**Newcastle Power Station (SSI-9837)
Request for Additional Information**

I refer to the Submissions Report for the proposed Newcastle Power Station Project, dated April 2020.

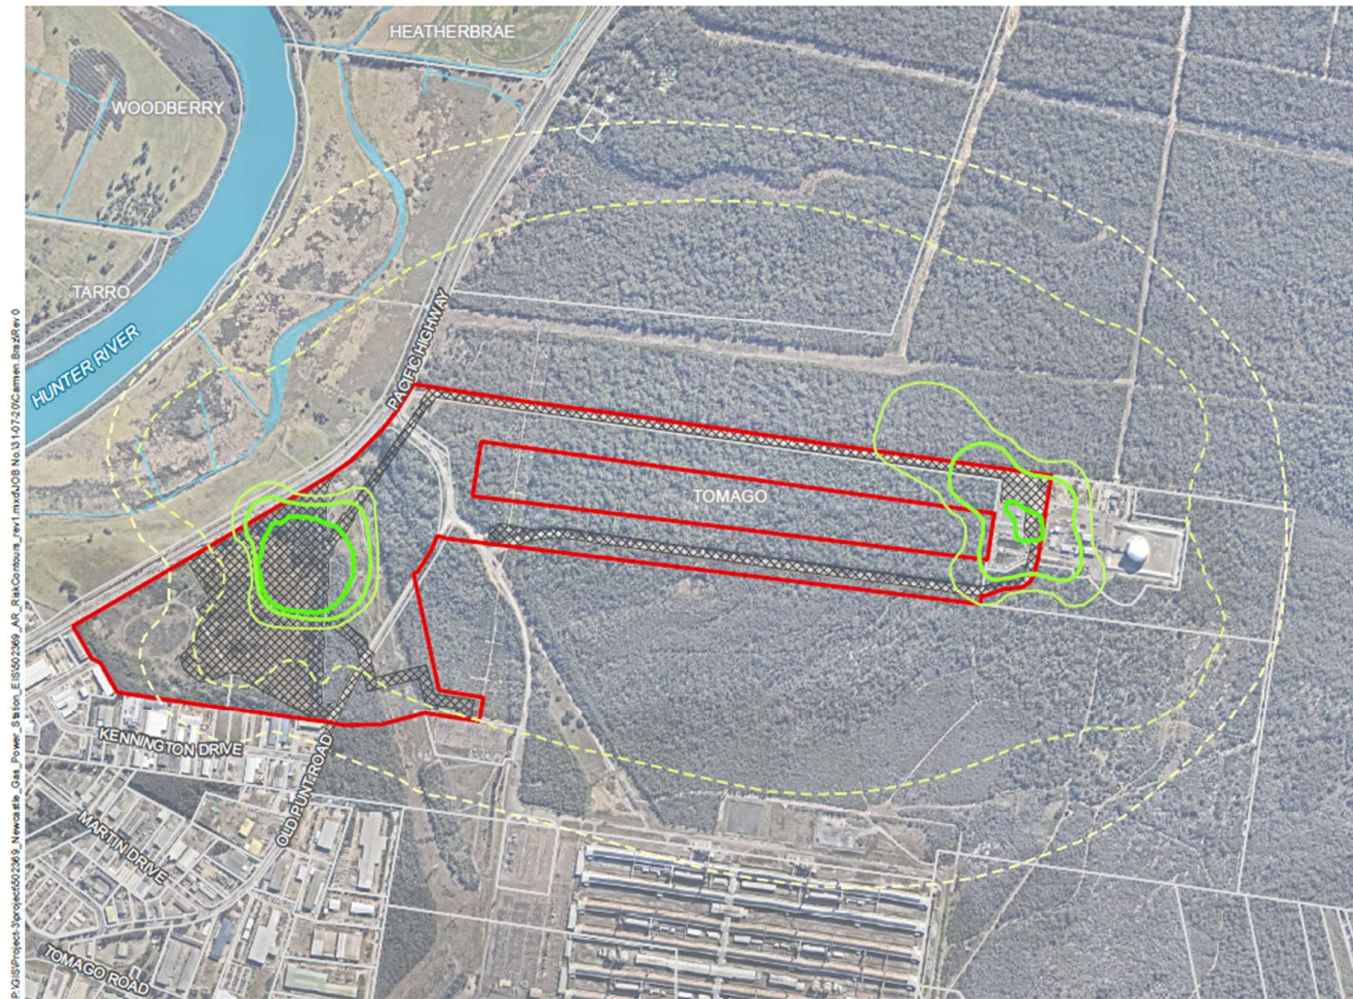
- A. clarification of how the ignition probabilities (81% and 40% for underground and aboveground sections) in Table 24 were used within the event tree in Table 19. Further details of how the 81% and 40% probabilities are apportioned for direct ignition (P1), delayed ignition (P2) and flame front acceleration (P3) are required;

- B. It is understood that for each underground section, jet fire, flash fire and VCE scenarios are analysed for 30, 50 and 110 mm release sizes. The choice of these release sizes appears to align with UK HSE RR1035 Table 72 for pin, small and large holes respectively. Please provide clarifications for the following matters, include full-bore rupture scenarios in the analysis, and revise the analysis as necessary:

- the quoted failure frequencies in Table 24 are different to UK HSE RR1035 Table 72;
 - the meaning of "frequency for pipe length of 0.47km" and "frequency for pipe length of 7.8km", and how these frequencies were used in the analysis are unclear; and

- no full-bore rupture scenarios were analysed in the revised PHA. These were analysed in the previous PHA; and

Based on the above matters, the individual risks outcomes in Figure 8 could be underestimated, possibly indicating that the proposal may not comply with the 50 pmpy individual fatality risk criteria for industrial land uses in HIPAP 4. Please update Figure 8 after revising the risk analysis to include items A and B above.
